BR/59/21/PL

10 Oakhurst 22-24 Upper Bognor Road Bognor Regis PO21 1FW

Change from studio flat to 1 No. 1 bed unit with dormer extension

A			
Client	H.O. Buschhaus Esq.		
Address	22 - 24 Upper Bognor Road : Bognor		
Drawing	Elevations	No.	6220:2
Scale	1:100	Drawn	B
		Date	FEB '21

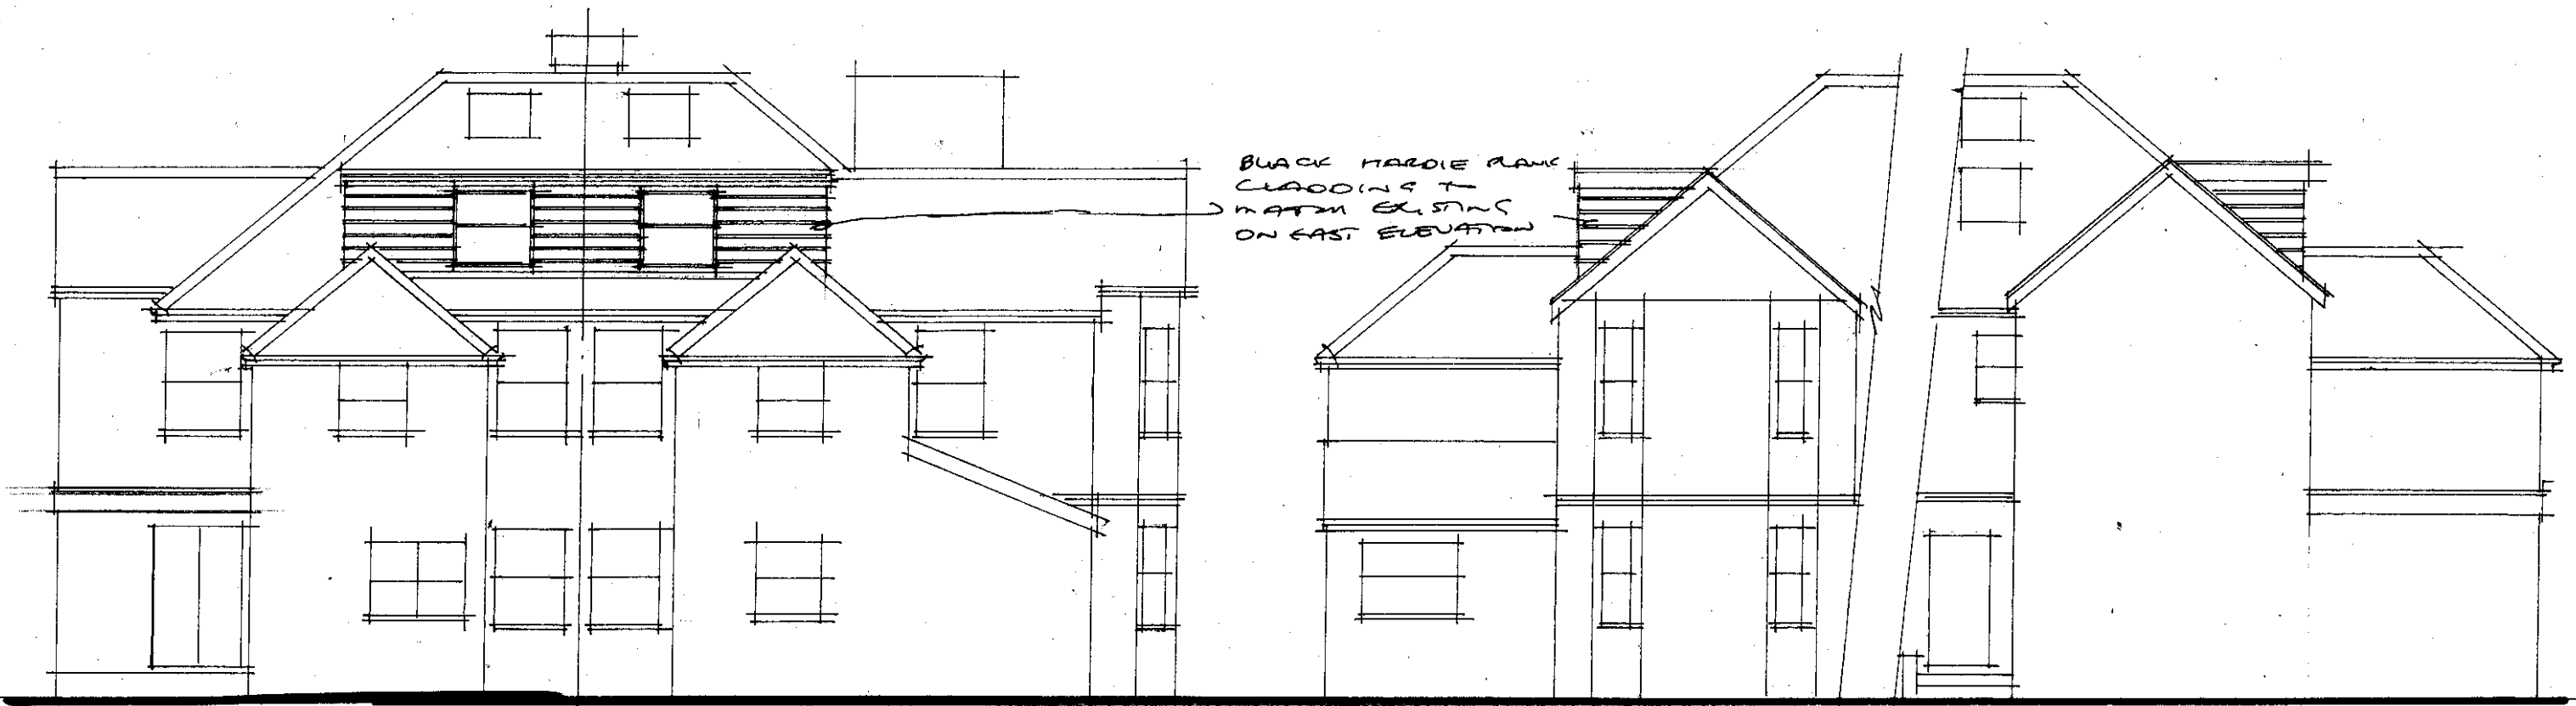
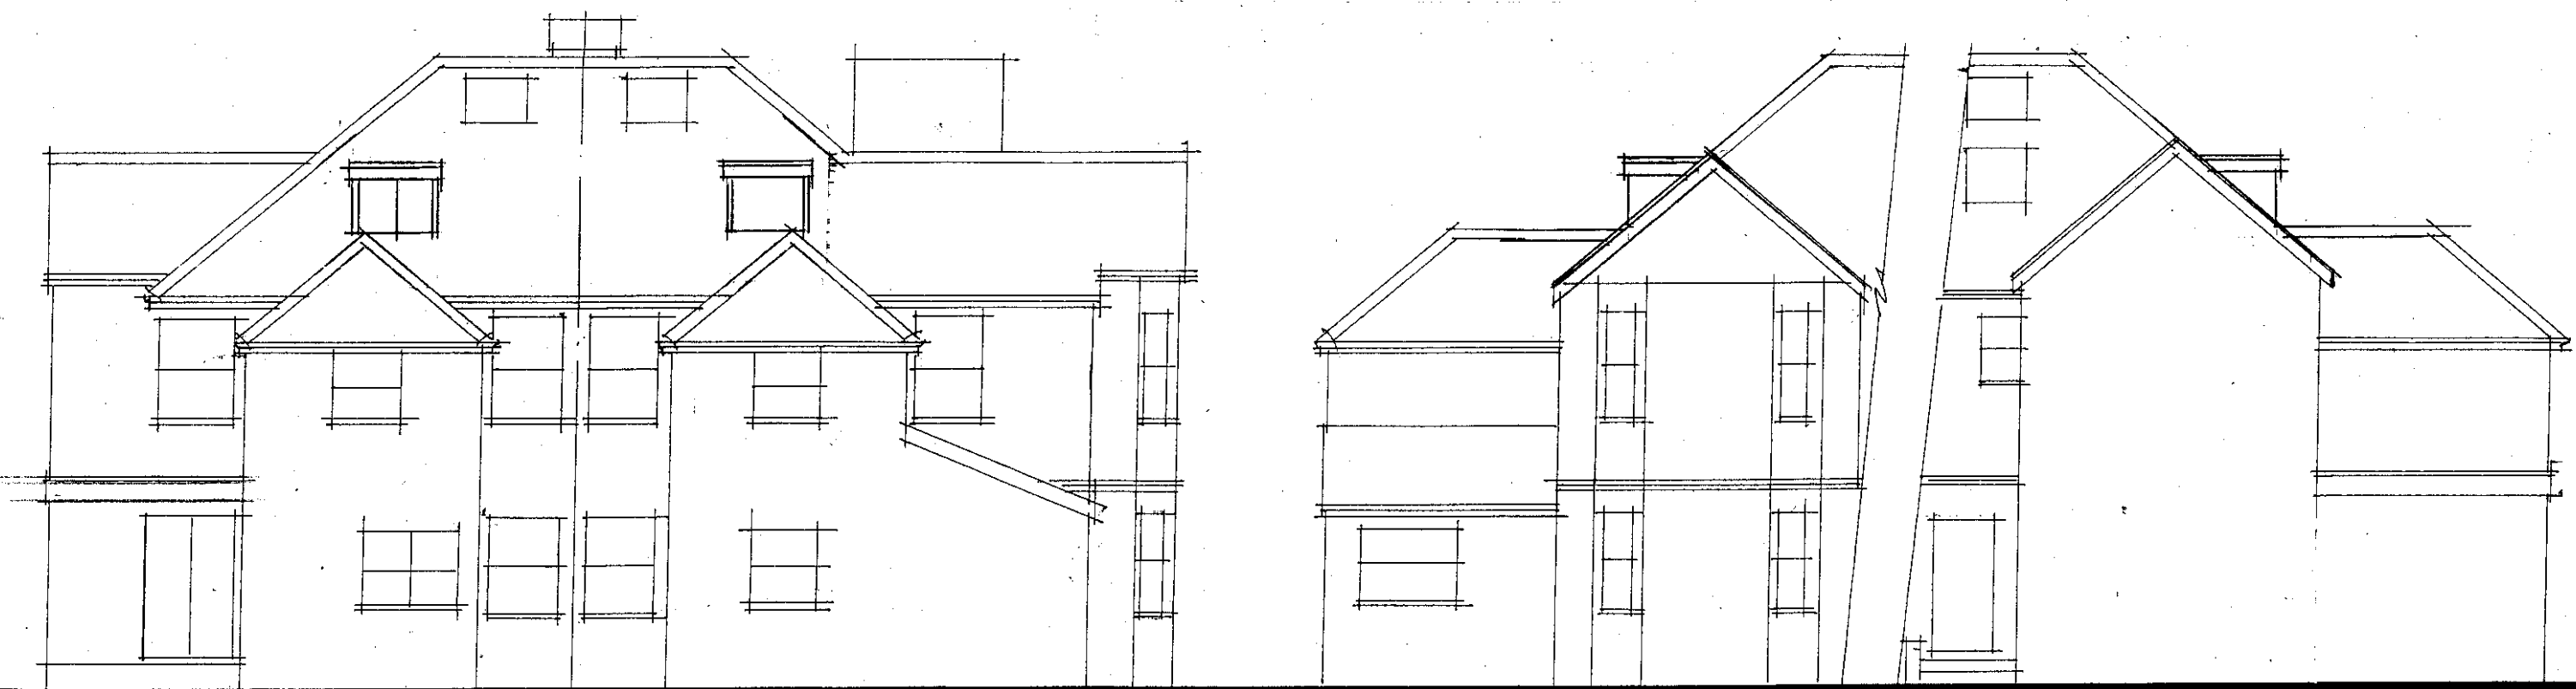
The proposal is for the change from a studio flat to a 1 bedrooomed flat unit with dormer extension. The dormer extension would be at the rear of the building and not visible form the public realm to the front. Whilst the design of the dormer could be improved, it is considered that its location is such that it would not be visible from the public realm, or in the context of the various listed buildings. As a consequence, it is considered that it will have a neutral impact.
